Kempsville Sanford Component Plant
298 Harvey Faulk Rd
Sanford, NC 27332

Builder: CRH Homes
Model: Dalton Res Garage SF Ceiling

CRH Homes
Dalton Res Garage SF CLG
CEILING JOIST LAYOUT

**SECOND FLOOR STRUCTURAL PLAN**  
SCALE: 3/16" = 1'-0"  
REFER TO "SD" SHEET(S) FOR STANDARD DETAILS AND STRUCTURAL NOTES

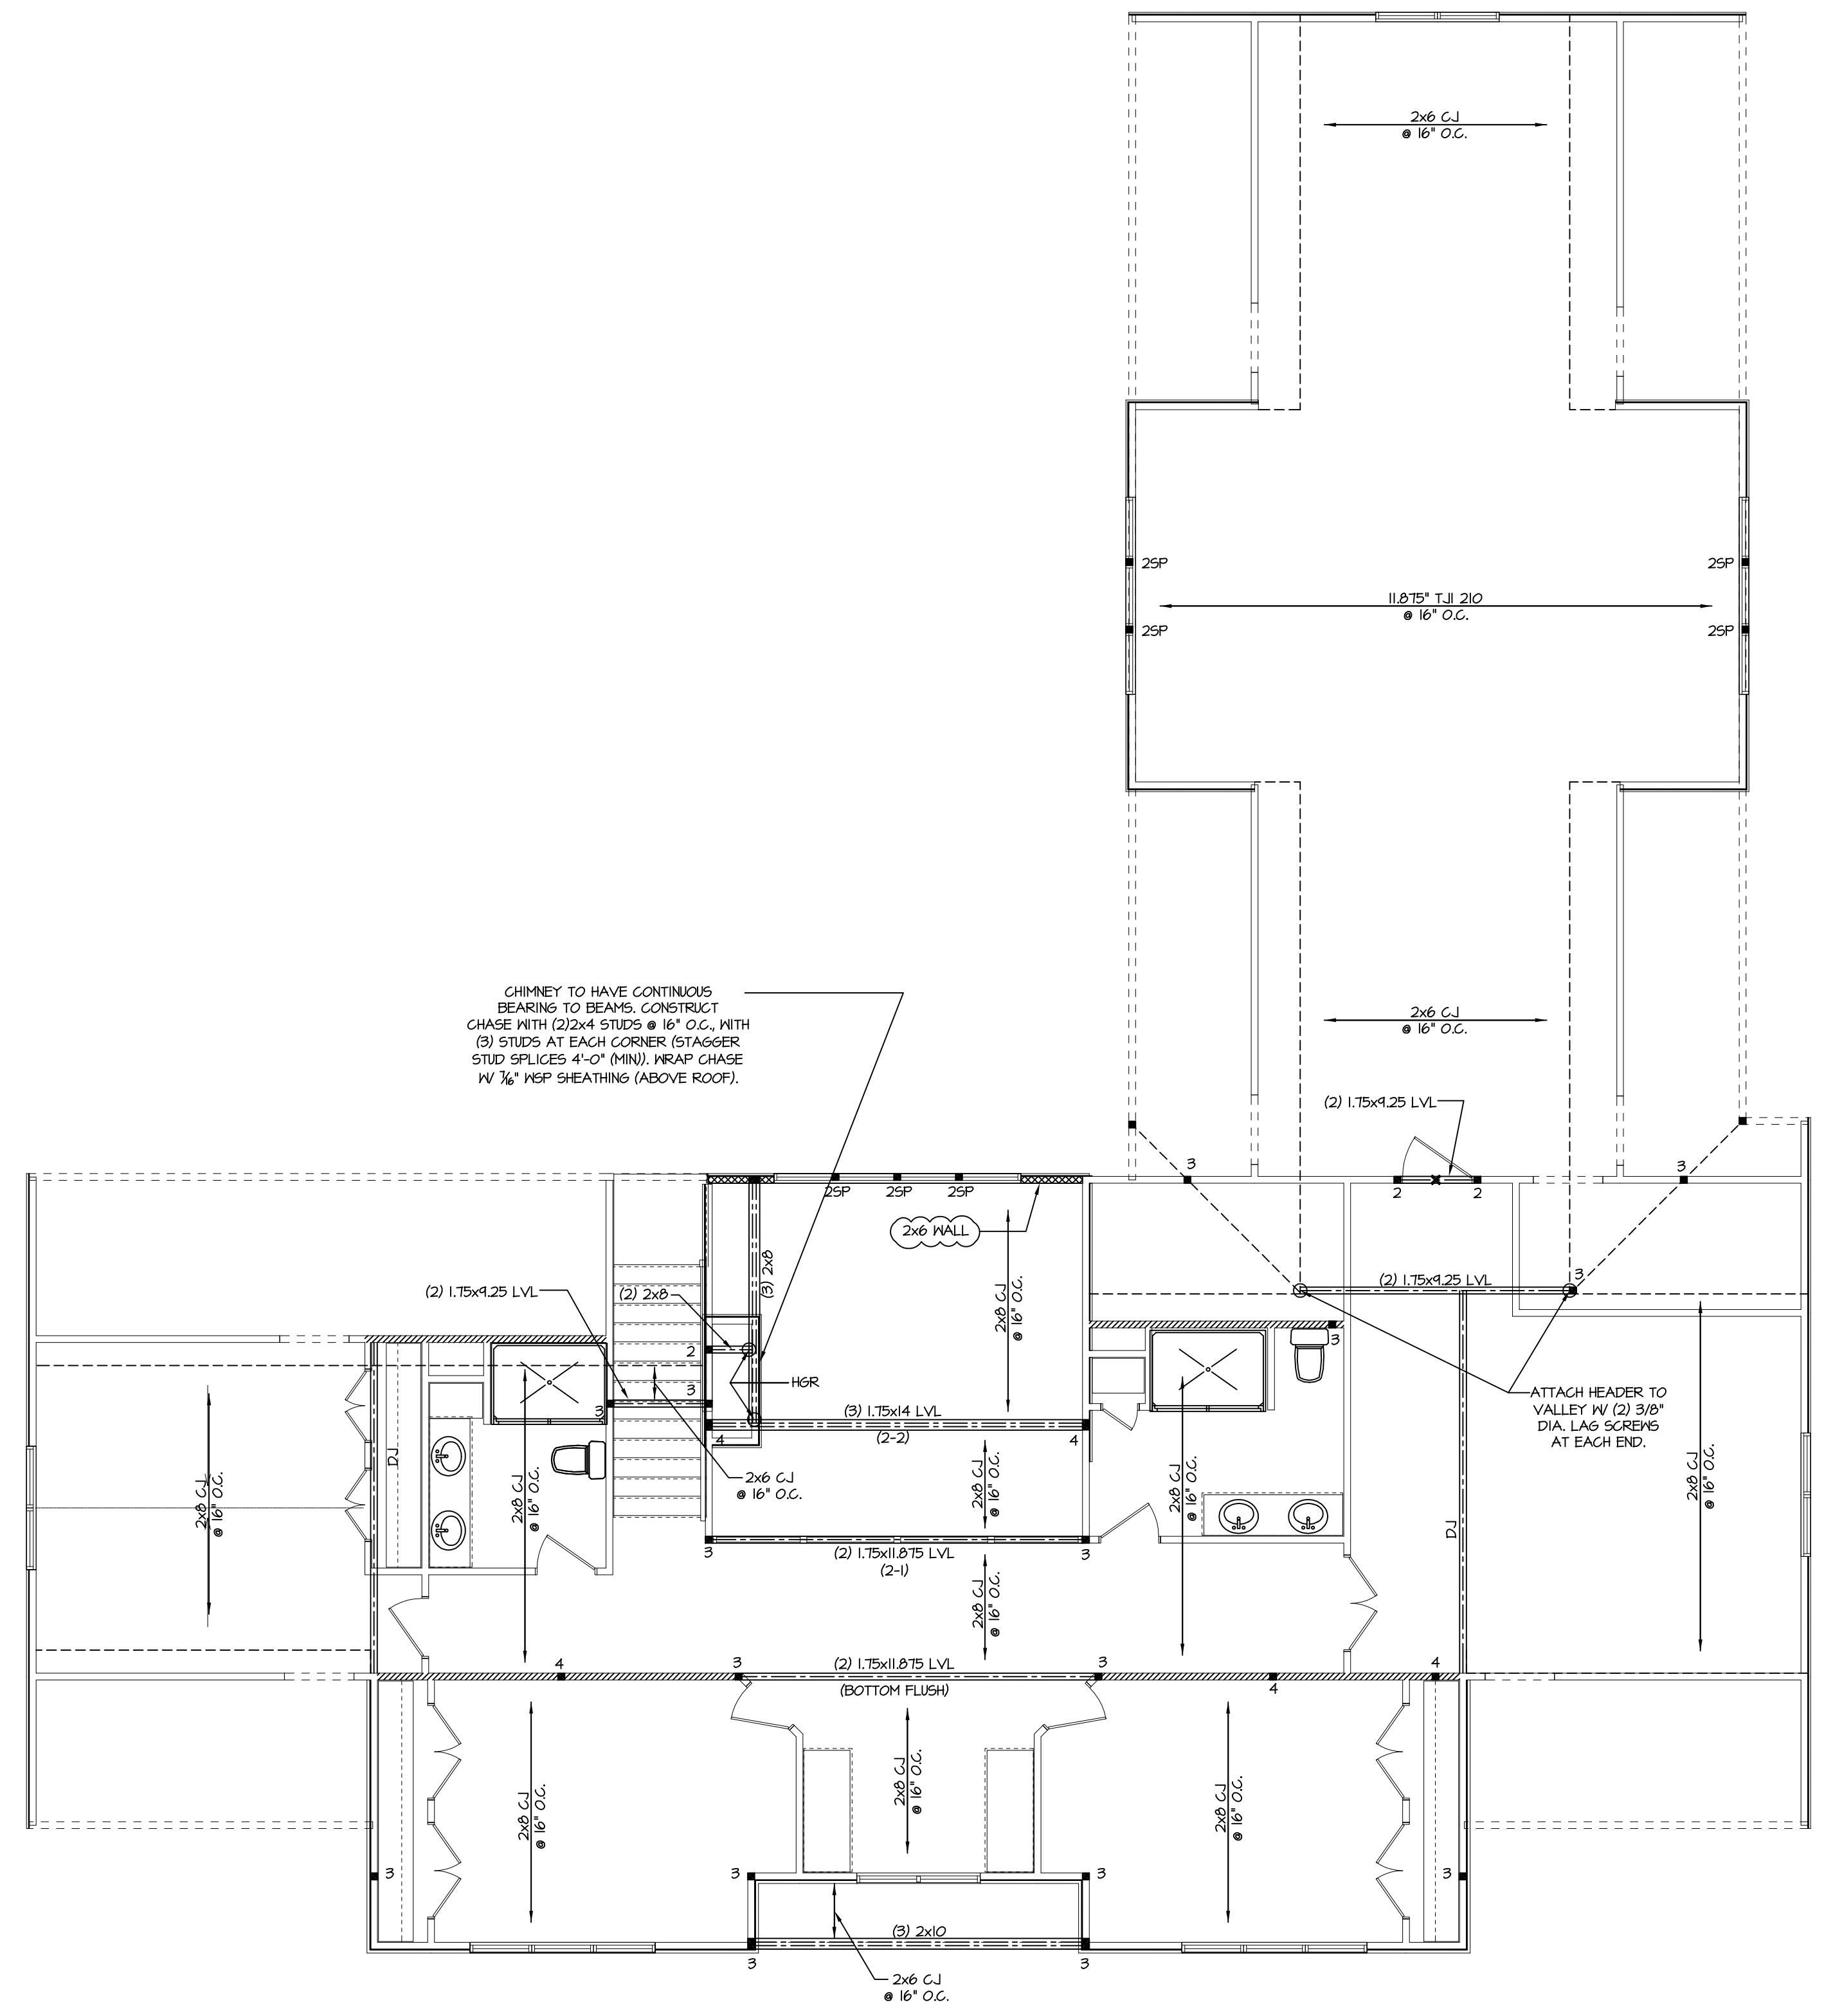
11 7/8" joists as called out on the prints will not work with PJI, 14" needed. Please confirm with EOR.
